Designer's Response

Project	Bonhams Field, Yapton
Project Number	23018

Comments Received From Arun District Council

Date of Response 29 March 2021 (Resubmission of Discharge of Conditions Application).

TITLE Storm Water Exceedance Route Plan			
SCALE	1:1000 @ A3	PROJECT No.	23018
REPORT TYPE	DTN	DRG. No.	05 B

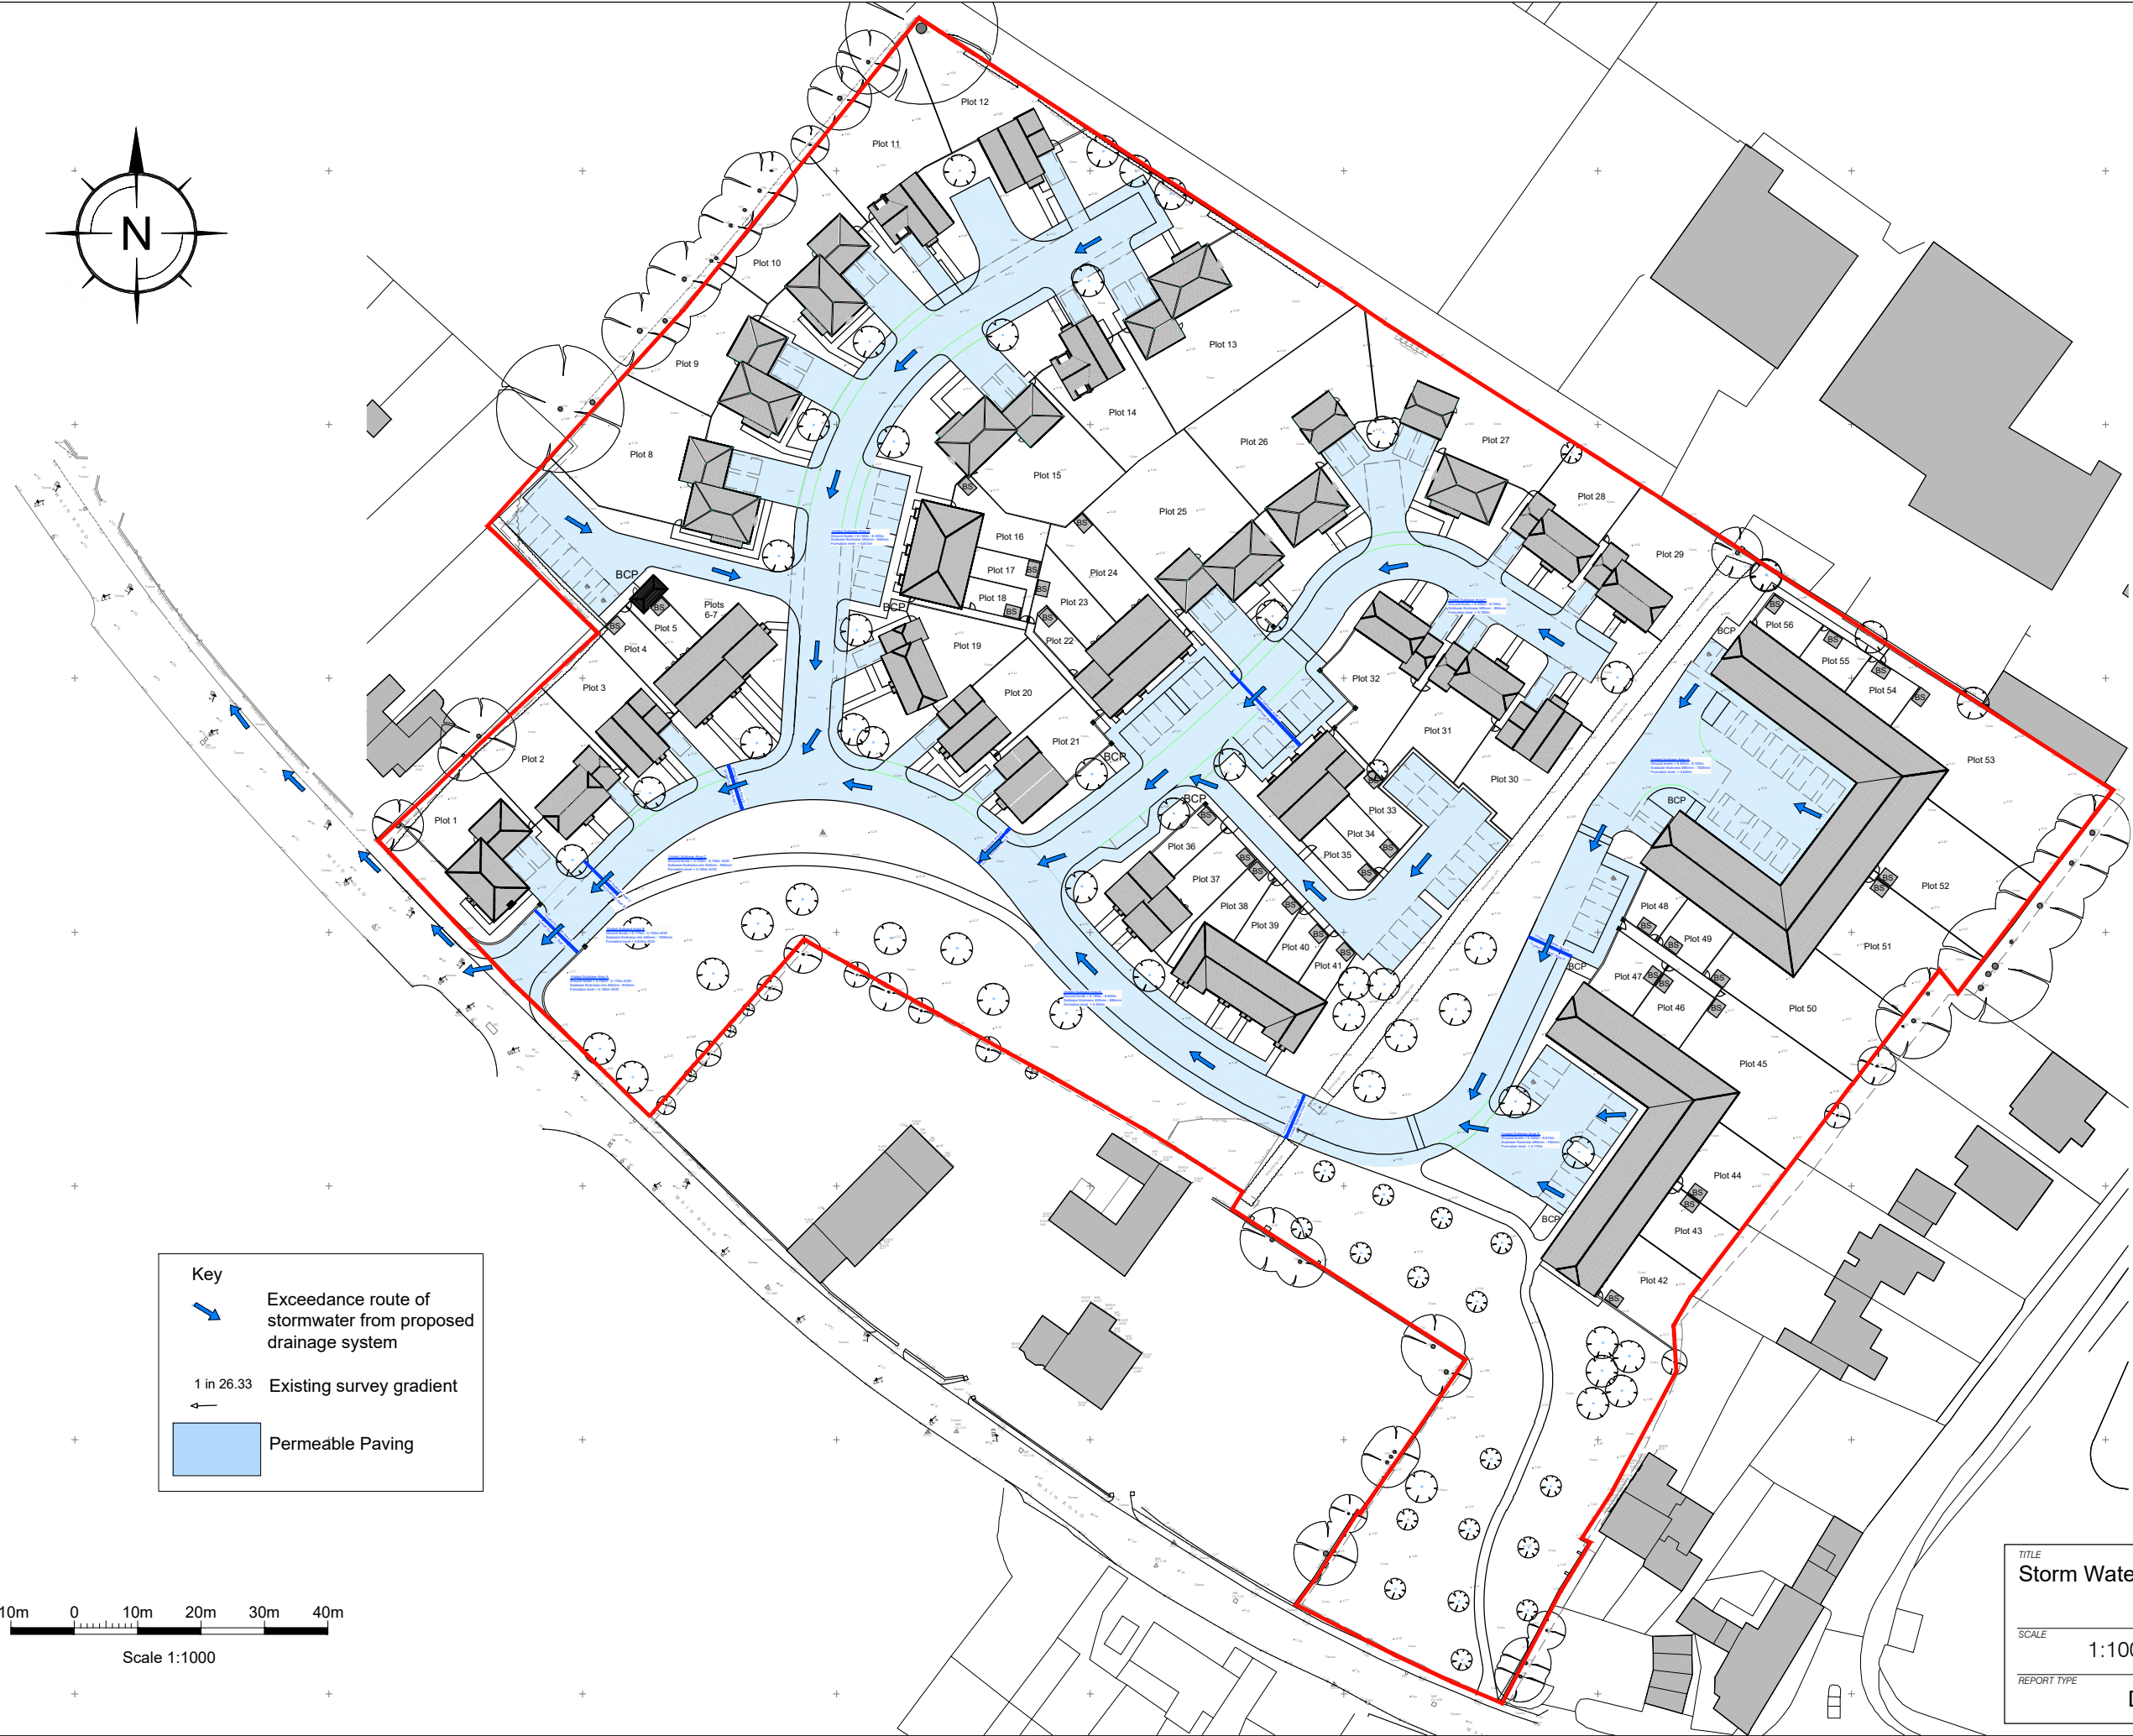
Comment / Query		Designer's response
7	<u>Arun District Council comment 5 January 2021</u> Please provide an exceedance flows drawing.	This is provided on Drawing 05 of the Discharge of Conditions Technical Note sent to you on Monday 4 January 2021. It should be noted that this scenario would only occur if there were a storm event larger than the 1:100 with a 40% climate change allowance, which has been used as the design event in this case and is regularly referred to as the 'exceedance event'
	<u>Arun District Council comment 12 January 2021</u> Apologies this does not load well for me due to the file size of the technical note. It only seems to show arrows off site. Please also indicate how exceedance flow will safely flow through the site.	We have updated the exceedance flow plan as requested, the latest plan is attached.
	<u>Arun District Council comment 16 February 2021</u> Okay.	
8	<u>Arun District Council comment 5 January 2021</u> Is terram to be provided to separate the sub-base from the clean stone on the permeable paving?	Yes, this has been provided on the latest revision of Drawing 1501B Construction Details which is attached.

PERMEABLE CONCRETE BLOCK PAVING
CARRIAGEWAY & DRIVE CONSTRUCTION DETAIL
Scale 1:20

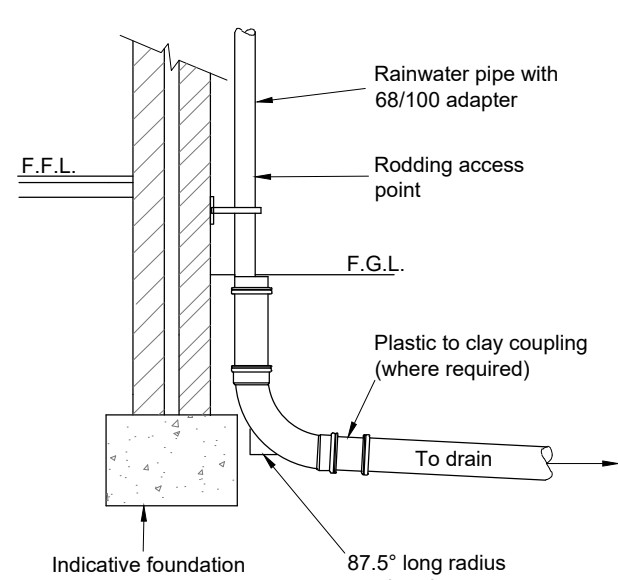
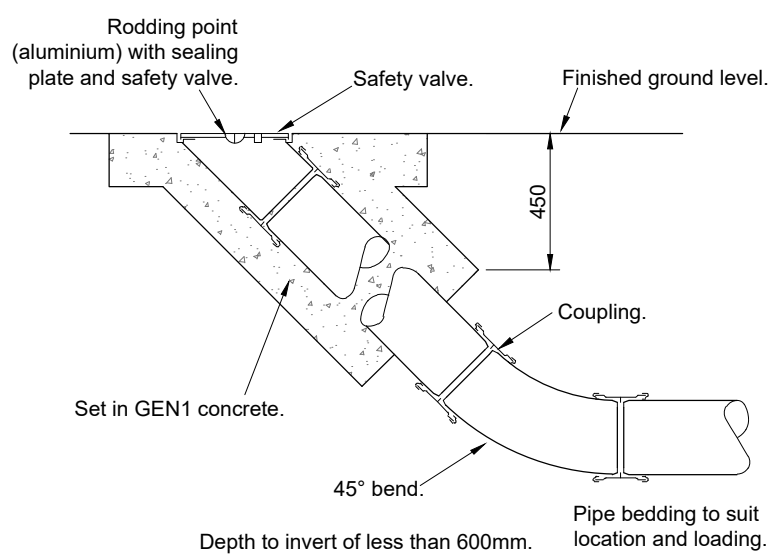
Comment / Query		Designer's response
1	<u>Arun District Council comment 5 January 2021</u> You have indicated that sub-bases will be stepped in several locations and that baffles will be used. The construction detail says these baffles are to have a minimum height of 250mm. You have not allowed for these baffles in calculations. I have completed some hand calculations based upon baffles at 250mm in Area B and it appears that flooding would occur at the bottom. Please could you review all required baffle heights-	The sub-catchment baffles have been removed and a flat formation will be introduced as per the main catchments. Updated calculations are provided to reflect the new formation level where required.

Comment / Query		Designer's response
	<u>Arun District Council comment 12 January 2021</u> Okay. The baffle is stated to always be 450mm deep, yet you have two catchments where water level will exceed this. Should the baffle height be adjusted in these two catchments?	We have updated the construction detail and included a note that the baffle height will vary based on the minimum depth of the subbase shown on the General Arrangement drawing.
	<u>Arun District Council comment 16 February 2021</u> Okay.	
9	<u>Arun District Council comment 5 January 2021</u> How is the formation to be protected during construction?	This is referenced within Section 3.3 of the Discharge of Conditions Technical Note sent to you Monday 4 January 2021.
	<u>Arun District Council comment 12 January 2021</u> Please include a during construction detail on the detail drawings along with a note explaining at what stage the final construction is required. Are you confident that during construction you will not increase flood risk? Please also elaborate on when it is required for the final construction to be built.	We have updated this detail which provides a permeable surface during the construction phase, which will not only ensure that flood risk does not increase during construction but will also provide additional capacity beneath surface level compared to the existing made ground. The sacrificial layer will be removed from each area prior to the installation of the final geotextile, 3-6mm clean stone and block paving surface finish being applied.

Comment / Query		Designer's response
	<u>Arun District Council comment 12 January 2021</u> Okay, you didnt need to remove them just re consider heights, but the solution you have provided technically works.	Noted
2	<u>Arun District Council comment 5 January 2021</u> Some areas appear to achieve insufficient storage depths in reality. I.e. taking invert levels and construction depths the required formation level exceeds that stated on plan. Please review.	We have reviewed this and updated some catchments where the lowering of formation levels is required to achieve the minimum 450mm thickness throughout to provide sufficient thickness for an assumed CBR value of between 2-5%. Other than Catchment F and H which require 477mm and 505mm thickness of voided subbase, surface water storage for all other catchments require between 180mm to 413mm of void subbase for the attenuation of surface water. A flat formation is to be used throughout all catchments and the construction detail on Drawing 1501B has been updated

CATCHPIT CHAMBER
(Scale 1:20)

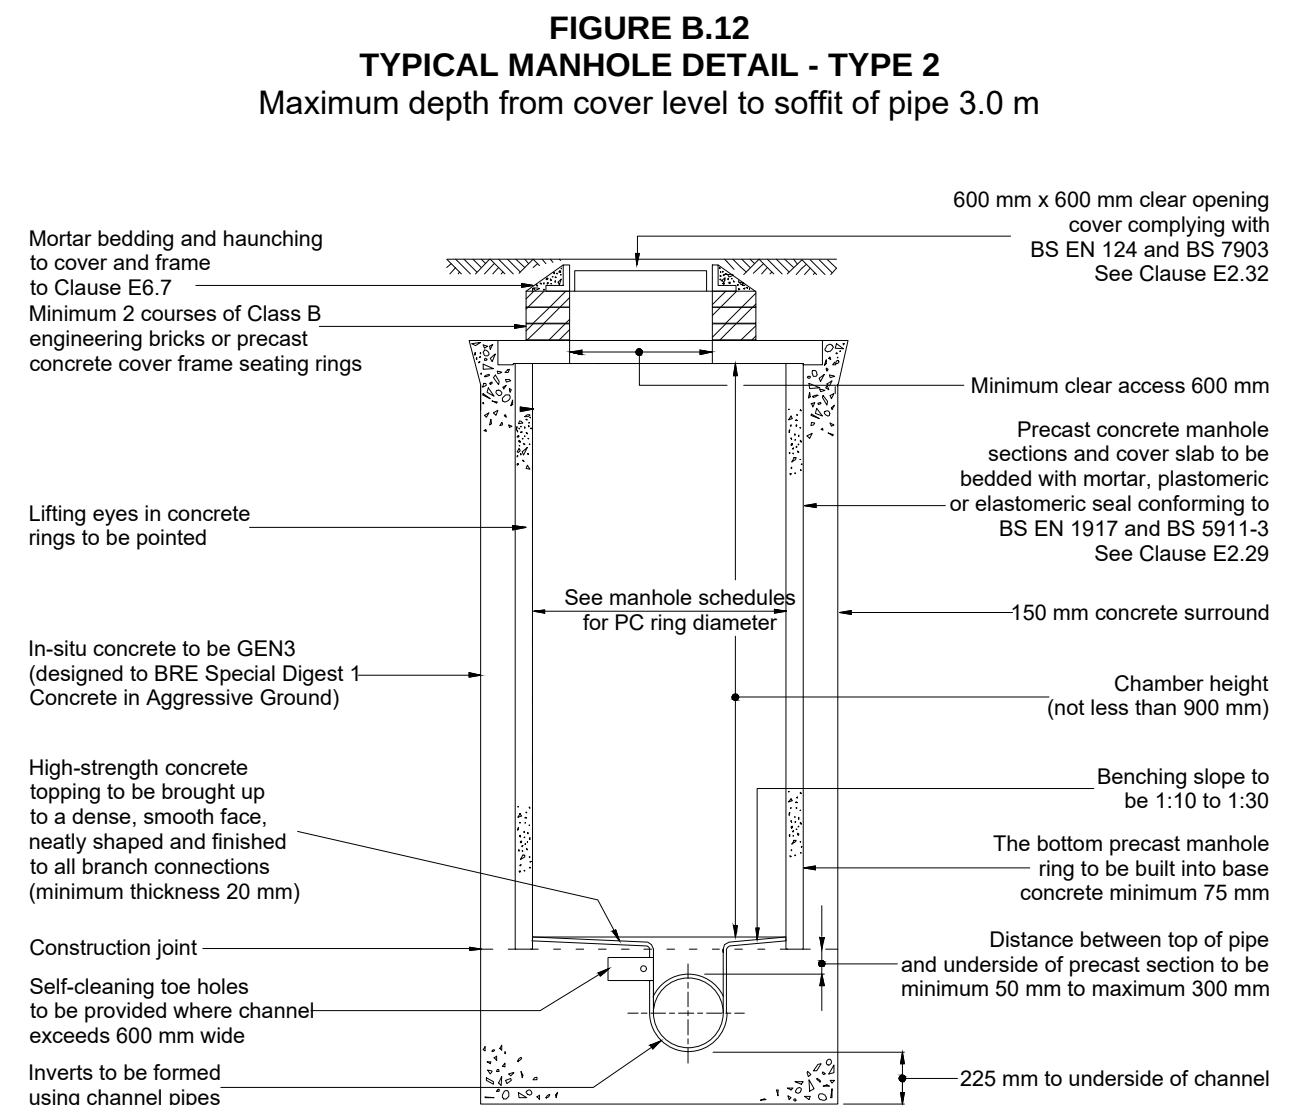
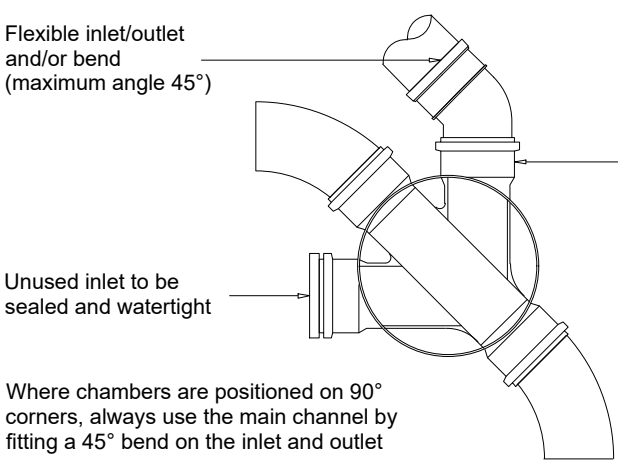
Comment / Query		Designer's response
5	<u>Arun District Council comment 5 January 2021</u> I note that in areas G and H you are proposing to locally deepen the sub-base around diffusers. Inlets should be set above the 1 in 10 year plus 40% cc event water level, they certainly should not be set below the base. Please reconsider the design here and check all areas have inlets set above the 1 in 10 year plus 40% climate change water level.	Further to the revisions above we have removed the locally thickening with the diffuser tanks have now been placed just above the formation level in these catchments, which is the highest point the diffuser tank can be set to ensure that minimum pipe falls and cover levels can be achieved.
5	<u>Arun District Council comment 12 January 2021</u> There are many areas where incoming connections are set below the 1 in 10 year, let alone 1 in 10 year plus 40% water level. This is not acceptable, please review. There is even one diffuser tank proposed below formation level. I note your comments about minimum falls, however your current proposals do not meet requirements. You may need to take some of the downpipes to more local features in some locations.	All diffusers are now either at or above formation level as discussed. This has been accepted elsewhere by Arun District Council including on Planning Application A/79/20/DOC approved in July 2020

<u>Arun District Council comment 16 February 2021</u>	
5	Policy requirement for major applications is to have all incoming connections set above the 1 in 10 year plus climate change event water level. The policy requirement comes from both the suds manual and BRE365.	As previously stated, the diffuser box detail proposed was submitted to and approved previously by Arun District Council Local Planning Authority under Planning Application A/79/20/DOC which was approved in July 2020.

Comment / Query		Designer's response
	<u>Arun District Council comments 16 March 2021</u>	
5	Policy requirement for major applications is to have all incoming connections to infiltration devices set above the 1 in 10 year plus climate change event water level. You are not meeting this requirement. You must meet the policy requirement.	We request that the above industry guidance is considered against the policy, robust evidence provided within our response of 3 March 2021 and details previously approved as part of Planning Application Planning Application A/79/20/DOC which was approved in July 2020. CIRIA C753 Report The SuDS Manual clearly demonstrates a detail in Figure 20.24 for permeable paving systems the SuDS Manual provides showing distribution boxes set at 50mm above the base of the permeable system with no reference to being above the 1:10 year event being made. The Arun District Council policy referenced conflicts with this industry recognised guidance. We have designed in accordance with Chapter 20 of CIRIA Report C753 The SuDS Manual, which is the most suitable industry guidance in this instance.

Comment / Query	Designer's response
5	Regarding the reference to BRE365 and The SuDS Manual, BRE365 was produced in 1991, specifically for the design of traditional concrete ring and trench soakaway systems in which the design criteria is the 1:10 year event. Due to the depth of the traditional soakaway systems, the incoming connection would be traditionally set at the top of the soakaway, typically no less than 1m below ground level. CIRIA C753 Report The SuDS Manual only shows examples of incoming connection above the 1:10 year storage for traditional soakaway systems. This is not directly comparable to the use of a shallow permeable paved drainage system and there are no requirements within The SuDS Manual for the 1:10 year event to be stored below the incoming connection. For permeable paving systems the SuDS Manual provides a detail in Figure 20.24 showing distribution boxes set at 50mm above the base of the permeable system with no reference to being above the 1:10 year event being made.

Comment / Query	Designer's response
5 The suds manual references that incoming flow to infiltrating structures should be free and unimpeded.	We cannot find the reference in the SuDS Manual to which Arun District Council has referred in their response. The following are the closest comments we have found, but they do not confirm the need for an inlet to a voided stone infiltration system to be set above the 1 in 10 year rainfall event. The SuDS manual notes <i>'Are there any constraints to water entry into existing pavement sub-base sections (on or adjacent to the site)?'</i> and that all inlets should be designed to <i>'deliver the required maximum flowrate freely from the upstream collection system'</i> In section 28.4 of SuDS Manual there is a section on inlets which notes <i>'Inlets raised above adjacent permanent water levels area generally recommended. Submerged inlets have the following potential risks:</i> • <i>Surcharging or backwater effect on the upstream surface water conveyance system'</i> The SuDS manual further provides an example of a diffuser unit discharging into subbase storage in Figure 20.24 of CIRIA Report C753 the SuDS Manual. This details a diffuser box which enters 50mm above the subbase formation level and is the detail included within the latest construction details drawing referenced in the latest Technical Note attached.

5 BRE365 makes you calculate the storage volume required between the base of the soakaway and the incoming invert for the 10 year event (based on the fact this is the design event in this section of the guidance), specifically "Storage must equal or be greater than inflow minus outflow, defined above, and is the required effective volume available between the base of the soakaway and the invert of the drain discharging to the soakaway."	As previously stated BRE365 is specifically for the design of traditional concrete ring and trench soakaway systems in which the design criteria is the 1:10 year event and is not directly comparable to the use of a shallow permeable paved drainage system. We have designed in accordance with Chapter 20 of CIRIA Report C753 The SuDS Manual.
